Memorandum

To: Jolene Wolfley and Jay Rodenbeck
From: Jacqueline Fishman, AICP
Date: September 11, 2023
Re: Major Amendment - PR-2021-005689; SI-2023-01391

This memorandum accompanies the Major Amendment for the project located at 7050 Constitution that was approved by the Development Facilitation Team (DFT) on August 30, 2023. The Site Plan is ready for final sign-off with the following changes having been made to the Site Plan, Landscape Plan, and Building Elevations:

SDP1-1.2

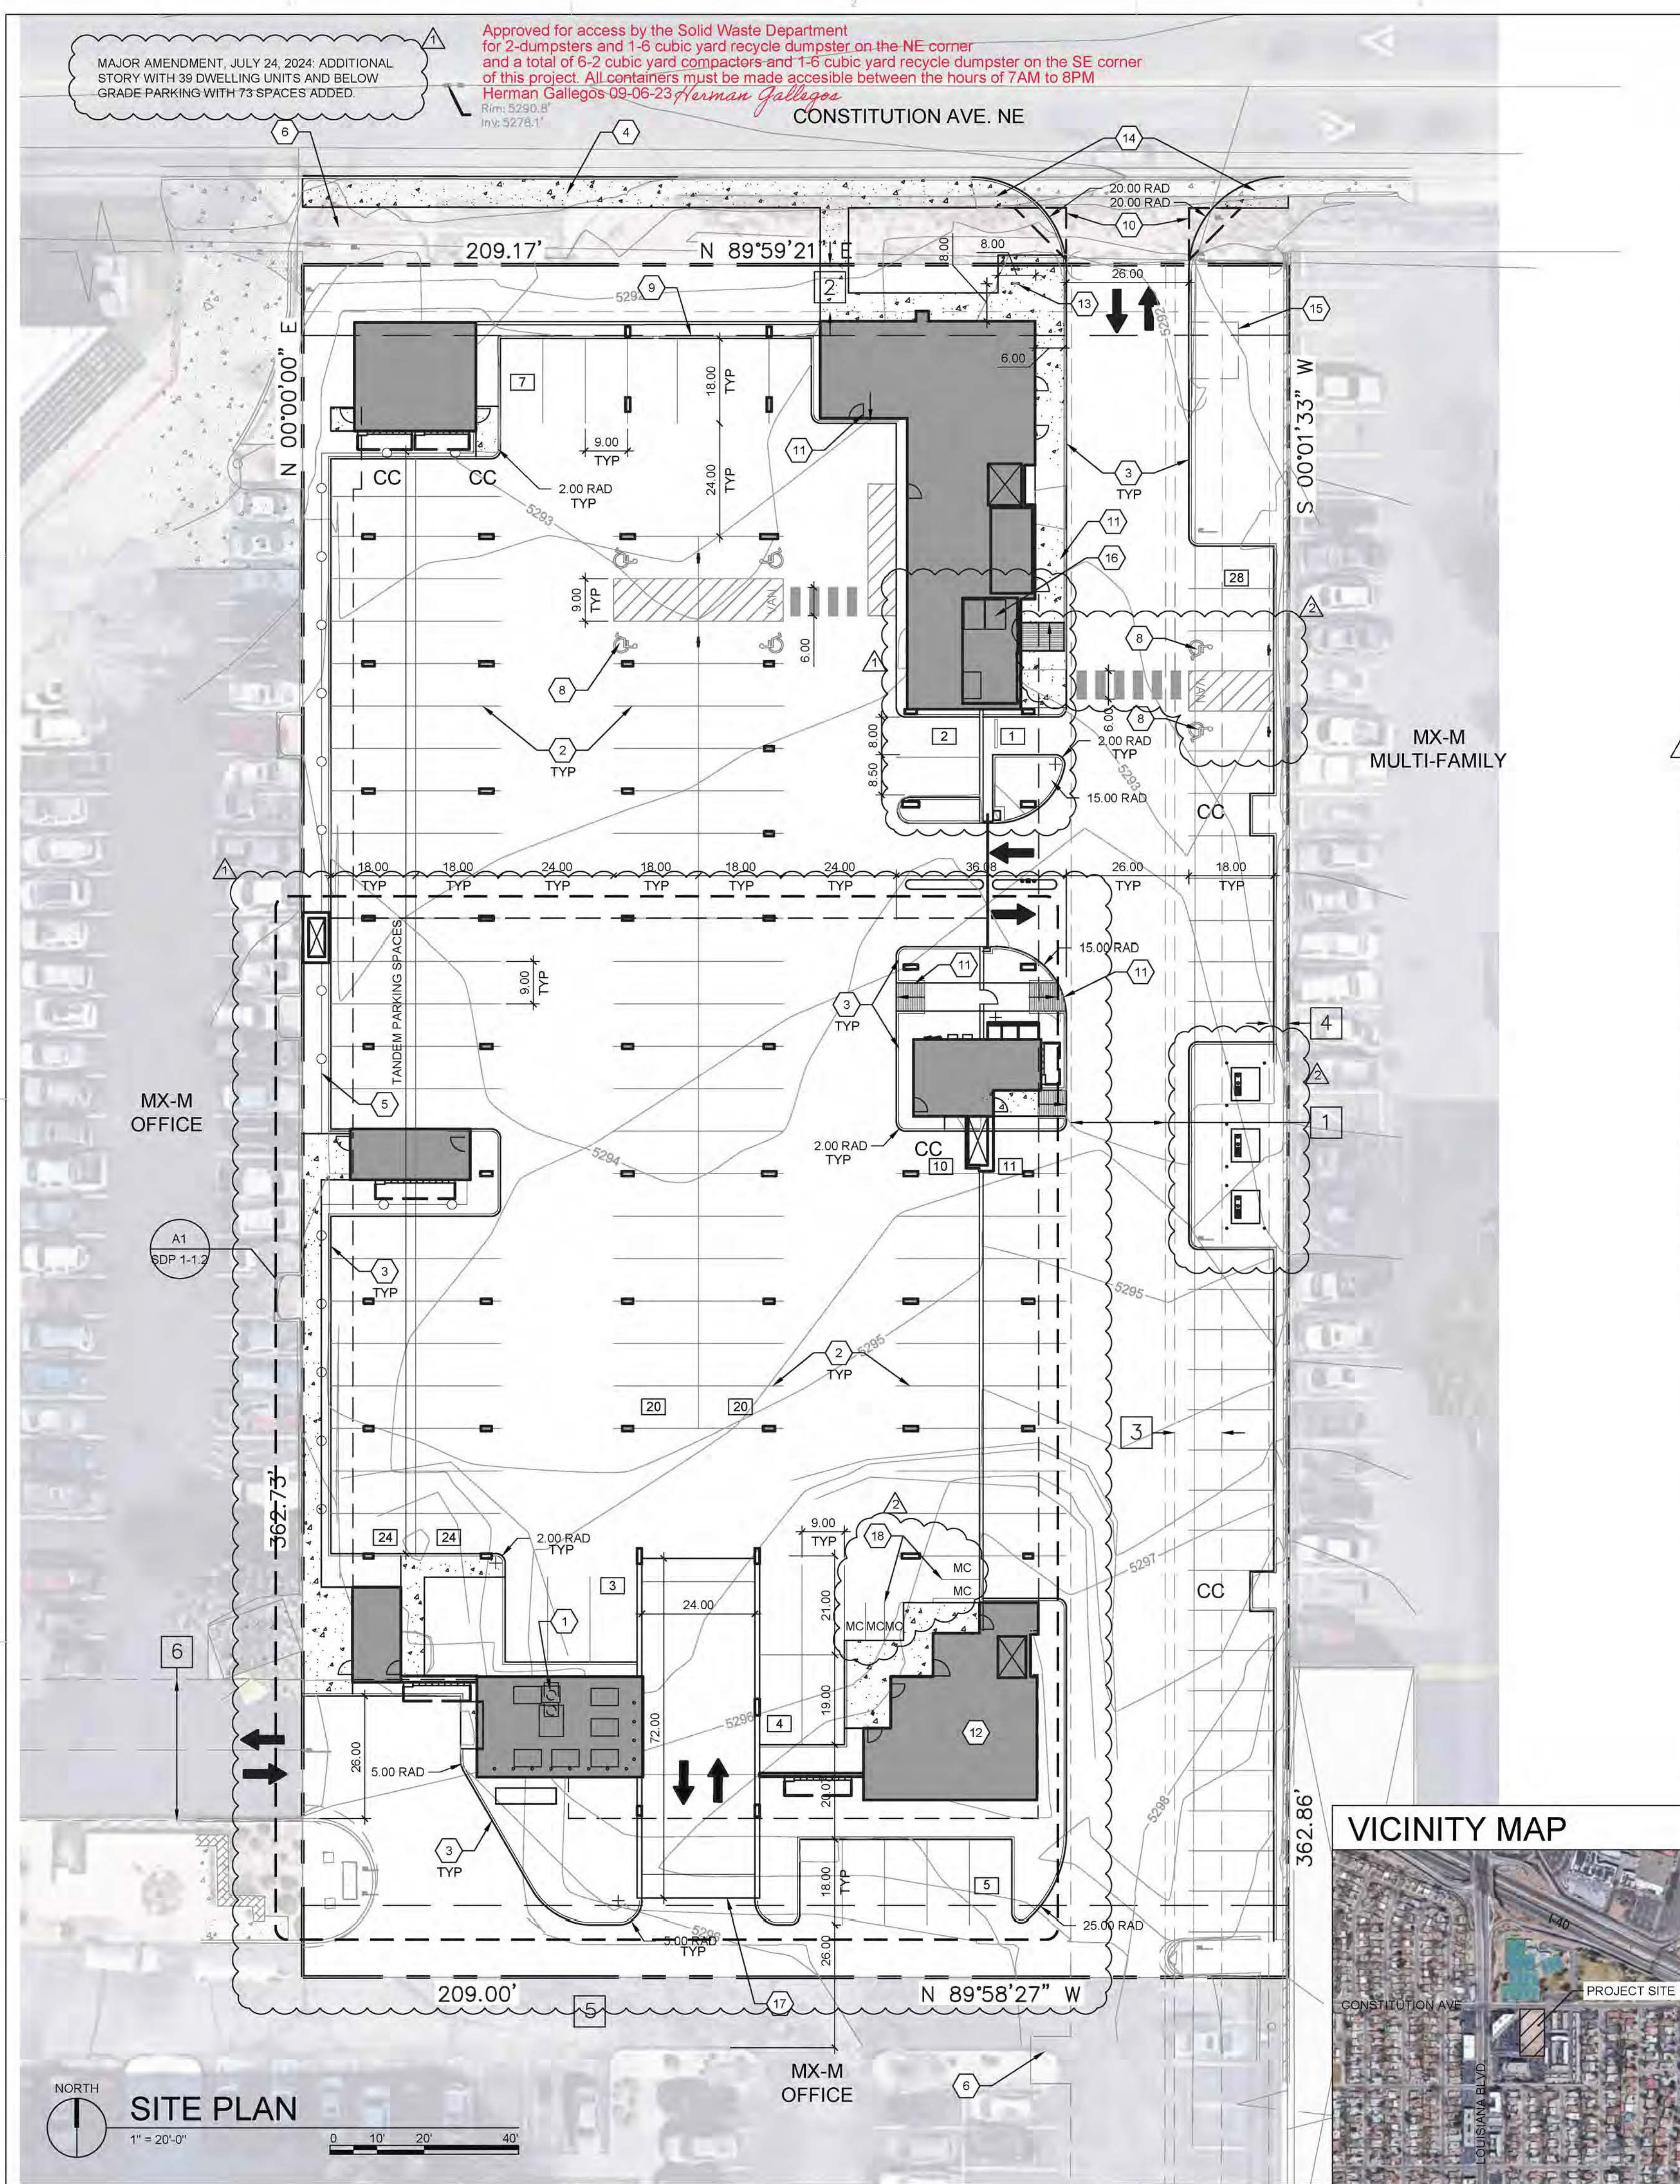
- 1) CPTED language has been added to the Site Plan, per 5-5(G)(1).
- 2) 5 motorcycle spaces have been added to the Site Plan, per Table 5-5-4 Minimum Motorcycle Parking Requirements.

LANDSCAPE PLAN

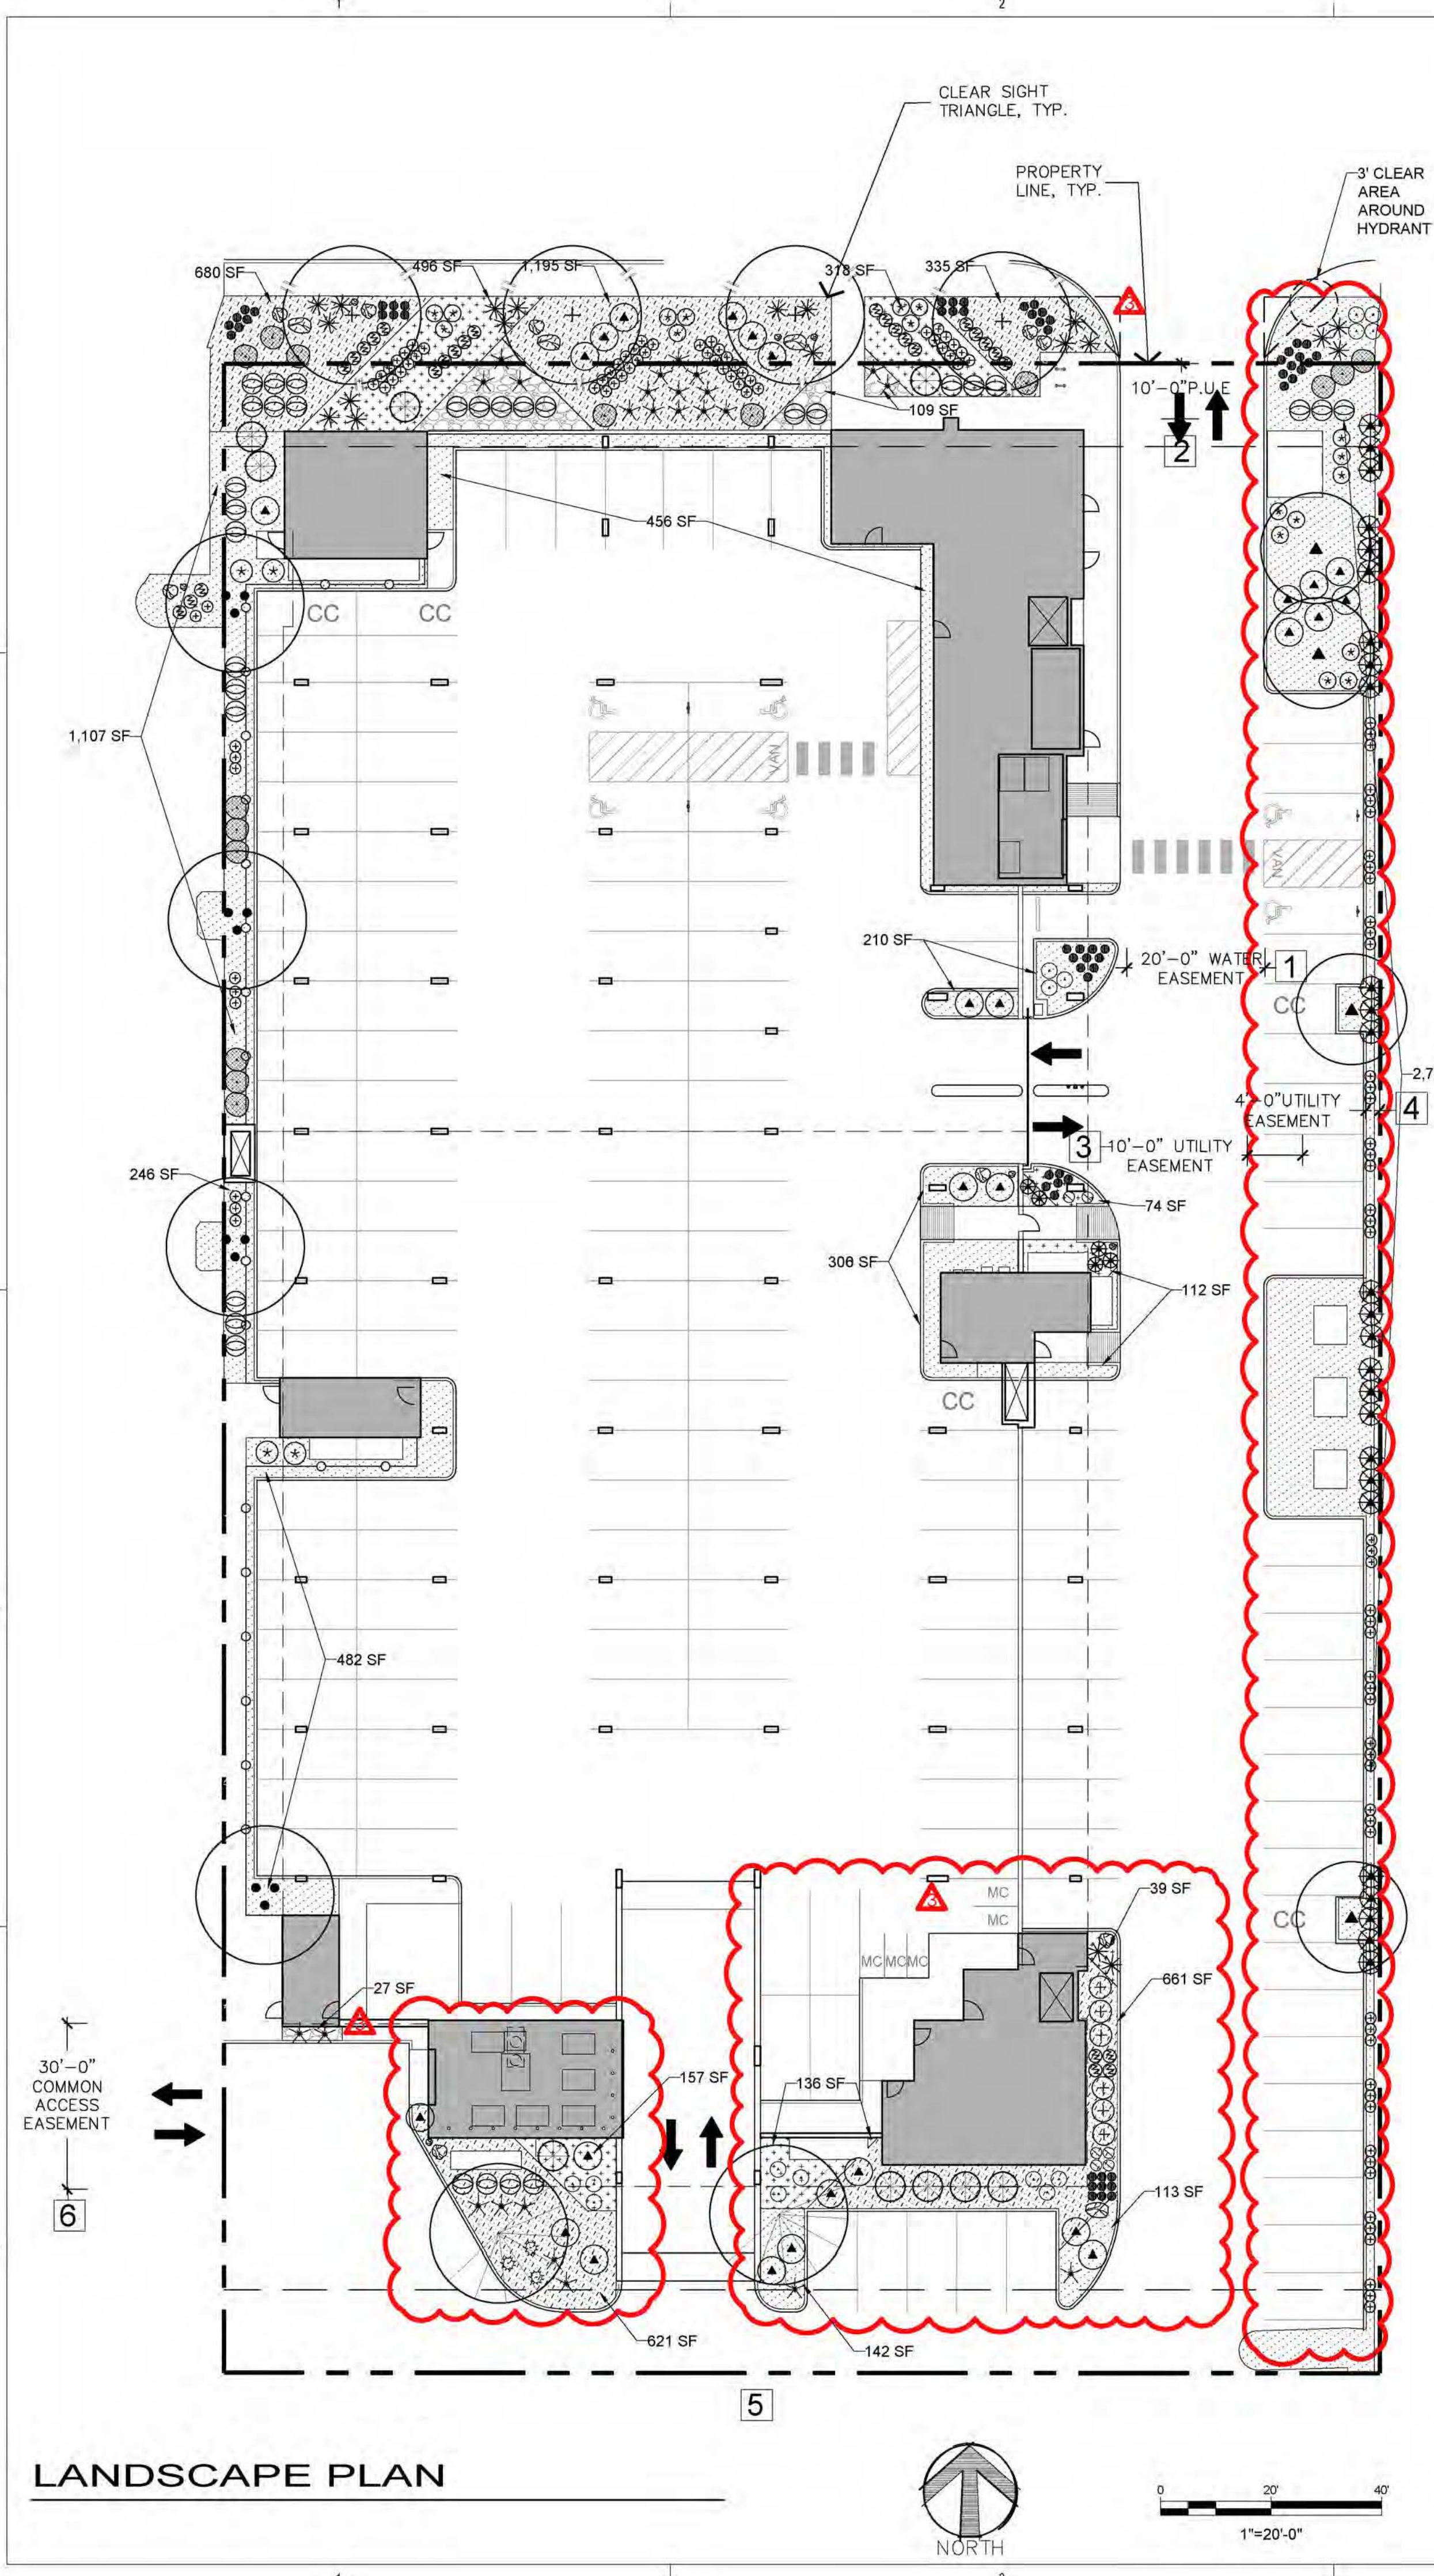
- 3) The groundcover on the Landscape Plan has been revised to reflect a maximum 68% gravel or crusher fines, with the remaining groundcover being bark mulch, per 5-6(C)(5)(c).

- 4) The typo on the Landscape Plan showing the installation size of *Quercus fusiformis* has been corrected to show 2-inch caliper installation size.
- 5) The street trees along Constitution on the Landscape Plan have been changed from Purple Leaf Plum, which was approved by the DRB in 2022, to Chinese Pistache due to its larger canopy.

- 6) The blade sign on the Building Elevations has been changed to project a maximum of 30 inches from the building, per Table 5-12-2.
- 7) The second floor Landscape Plan, sheet L1.2, has been added to the Site Plan set of drawings showing plant location, plant palette, and quantities, and the Landscape Plan, sheet L1.1, has been revised to reflect only the plant palette and quantities on the ground for clarity purposes.
